**FW: Request for further information K/16/26/HH**

From: Elaine Walby <[REDACTED]> **On Behalf Of** Planning.Responses
Sent: 05 August 2026 12:27
To: Terraquest <[REDACTED]>
Subject: FW: Request for further information K/16/26/HH

From: Fuller Architects <[REDACTED]>
Sent: 05 August 2026 10:21
To: Planning.Responses <[REDACTED]>
Cc: Fuller Architects <[REDACTED]>
Subject: Re: Request for further information K/16/26/HH

Drawing No	Revision
260032/ 01

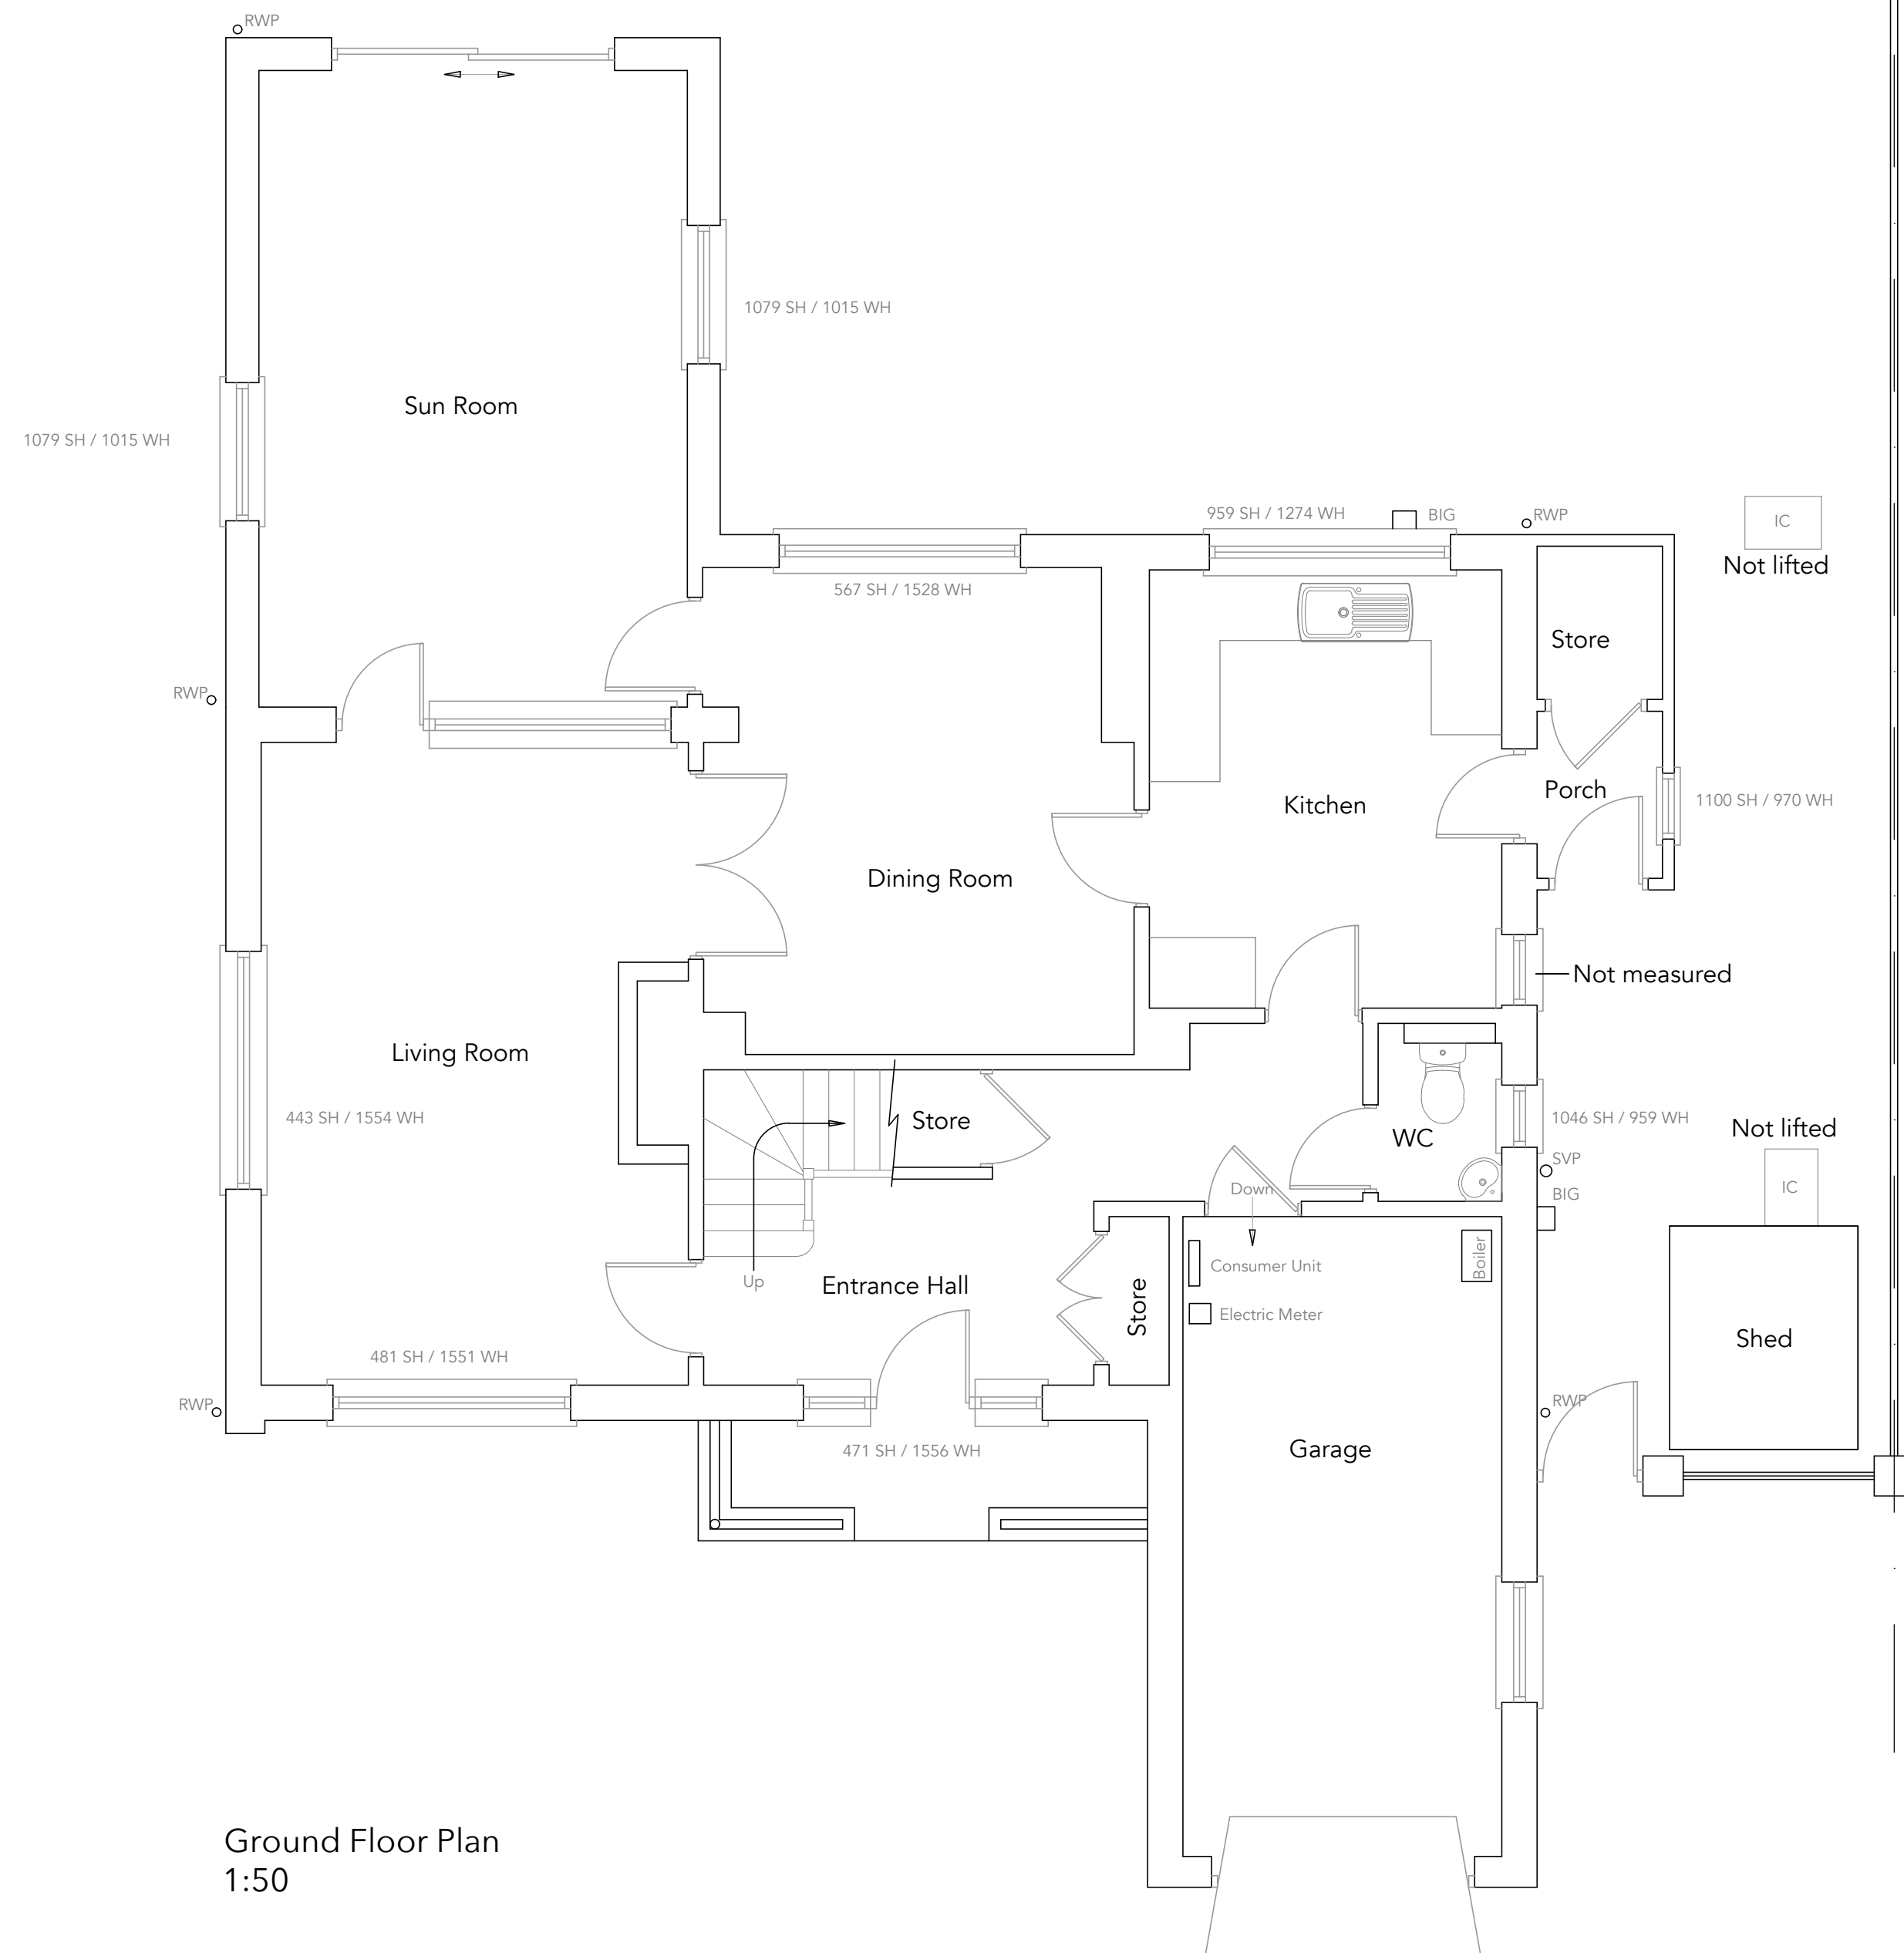
Regarding the Location and Block Plan, the Location Plan has been produced using the relevant OS data. The Block Plan shows the proposed roof plan, including the extensions, together with the distances to the site boundaries as required. I have also added dashed lines to indicate the extent of the existing roof line. If this is still not acceptable, could you please clarify what additional information you would like to see included?

With regard to the hatching, I have hatched the proposed new walls on the floor plans and shown only the proposed elements hatched on the elevations. If this is not what you require, I would be grateful if you could clarify exactly what it is you would like to see.
